DOC24/683156-4

**Oven Mountain Pumped Hydro Energy Storage (SSI-12422997)
EPA comment on Response to Submissions**

Thank you for the request for advice from Public Authority Consultation (PAE-75035987), requesting the review by the NSW Environment Protection Authority (EPA) of the proponent's Response to Submissions (RTS) for the proposed Oven Mountain Pumped Hydro Energy Storage project (SSI-12422997) at 9823 Kempsey Armidale Road, Carrai NSW 2440.

Oven Mountain Pumped Hydro Energy Storage Project  
Amendment Report  
OMPS Pty Ltd  
Figure 6.1

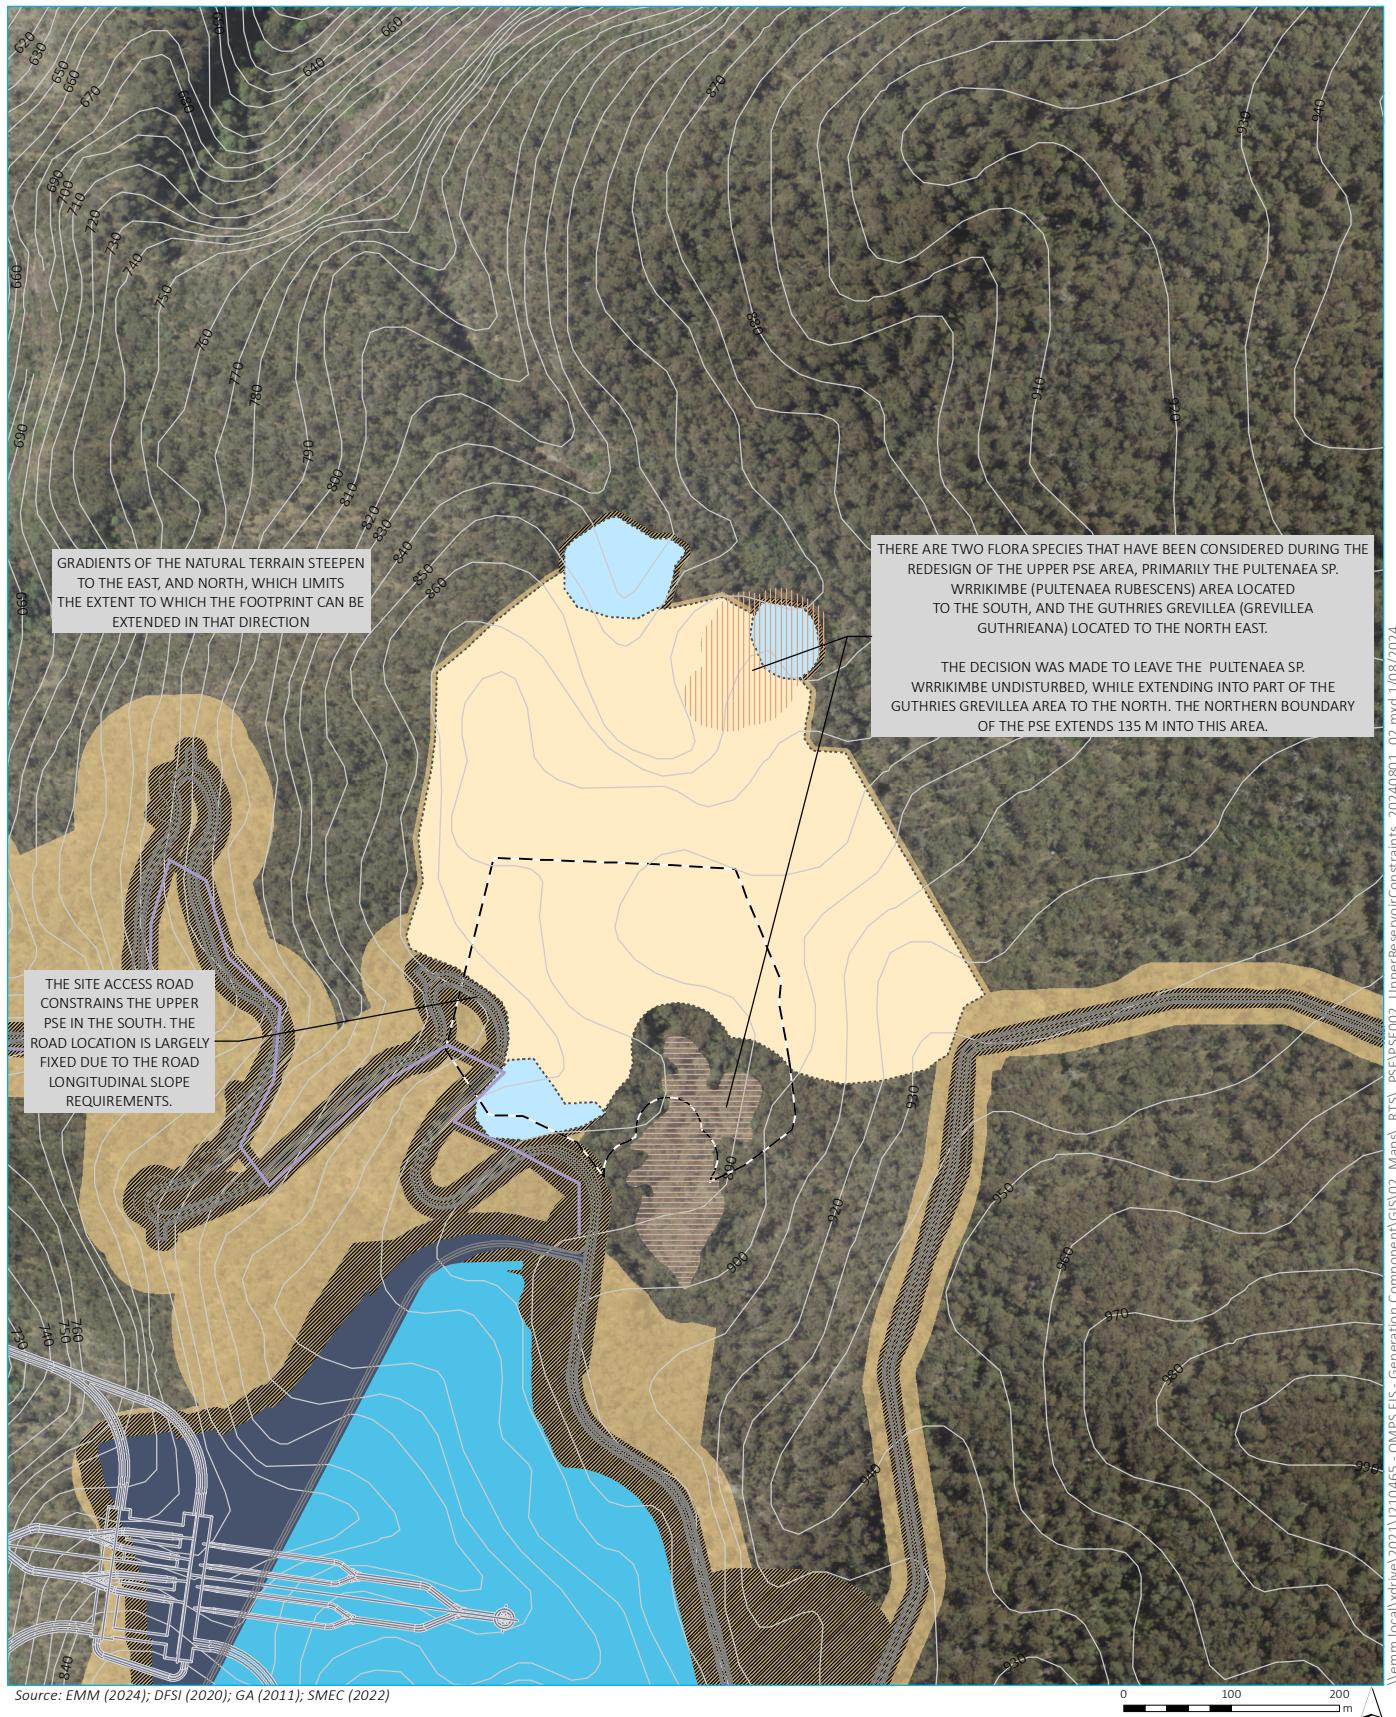
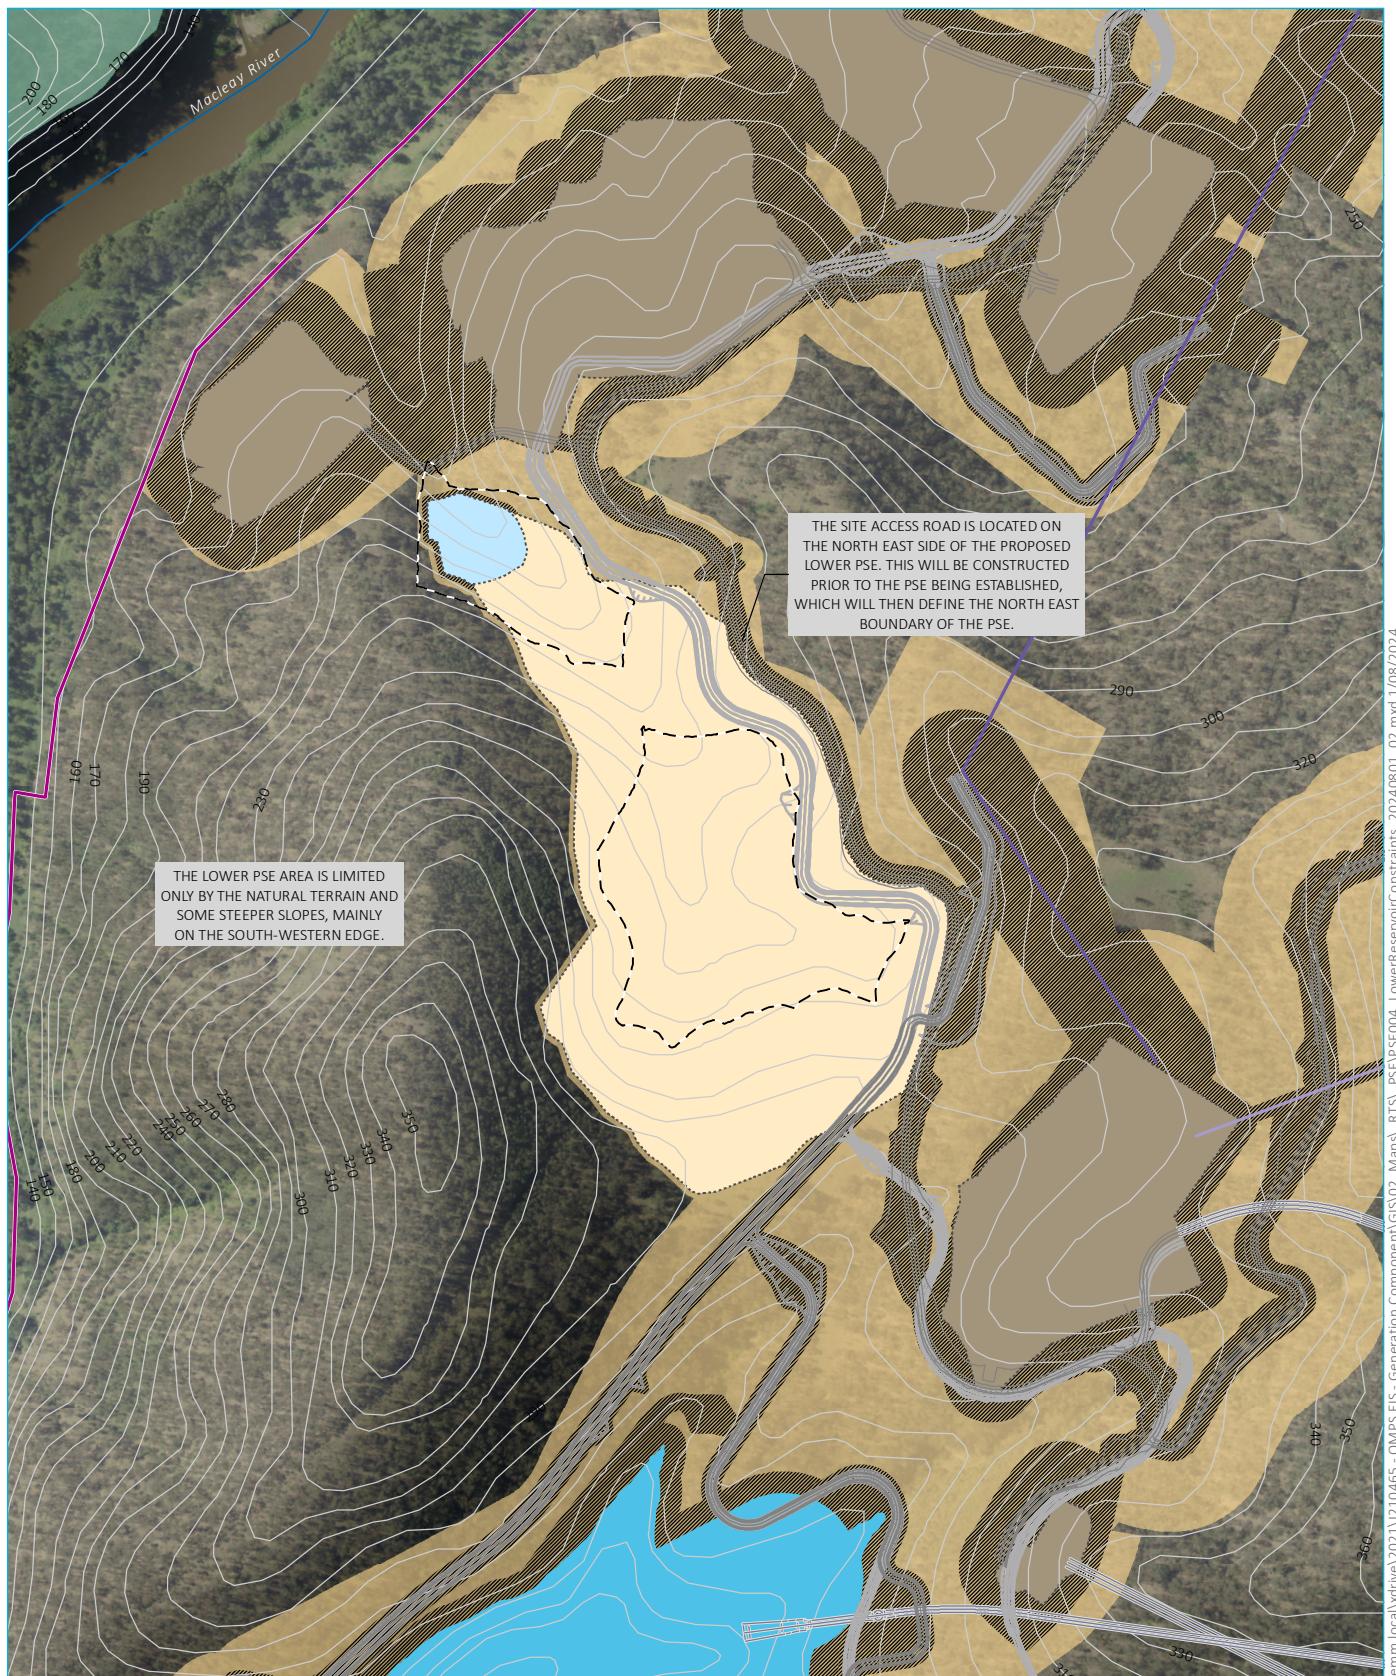
The submitted reports do not address the groundwater concerns identified in the EPA's October 2023 correspondence, and issues raised in the EPA's review of Environmental Impact Statement (EIS). Additionally, the proponent has amended the design and capacity of permanent spoil emplacement areas but has not suitably addressed or mitigated the potential impacts resulting from their construction.

There are no groundwater monitoring or mitigation measures presented in the Groundwater Impact Assessment or Permanent Spoil Emplacement report to evaluate groundwater quality impact management and mitigation, at the proposed Permanent Spoil Emplacement Areas (PSE). The RTS proposes that the Lower Reservoir PSE is amended with an increase in size and storage capacity. However, there are no current groundwater monitoring bores in the vicinity of both proposed PSE's and no additional groundwater monitoring bores are proposed to collect baseline data. Therefore, comparisons of infiltrated leachate to baseline groundwater quality cannot be determined.

1. Expand the groundwater monitoring network to assess impacts on groundwater during proposed and ongoing works including:
 - a) collect baseline data prior to determination by drilling new shallow groundwater monitoring bores upgradient of proposed spoil emplacements.
 - b) Include nitrates to the groundwater quality sampling suit for the Lower Permanent Spoil Emplacement where the proposed location for spoil from tunnel blasting activities to be placed.
 - c) It is noted that commitments are made to incorporate and update the existing monitoring network in Water Management Plans that are to be developed post determination. Inclusions of monitoring frequencies and groundwater quality constituents are also proposed.

2. Provide details of the proposed low permeability compacted surface. A detailed description of liner options should be provided to allow an assessment of how leachate related groundwater impacts will be managed during the project lifetime including:
 - a) descriptions of lining options
 - b) preferred materials
 - c) source of material
 - d) permeability assessments
 - e) construction details and liner thickness
 - f) conditioning details
 - g) how the preferred liner option is to be verified prior to emplacement commencement.
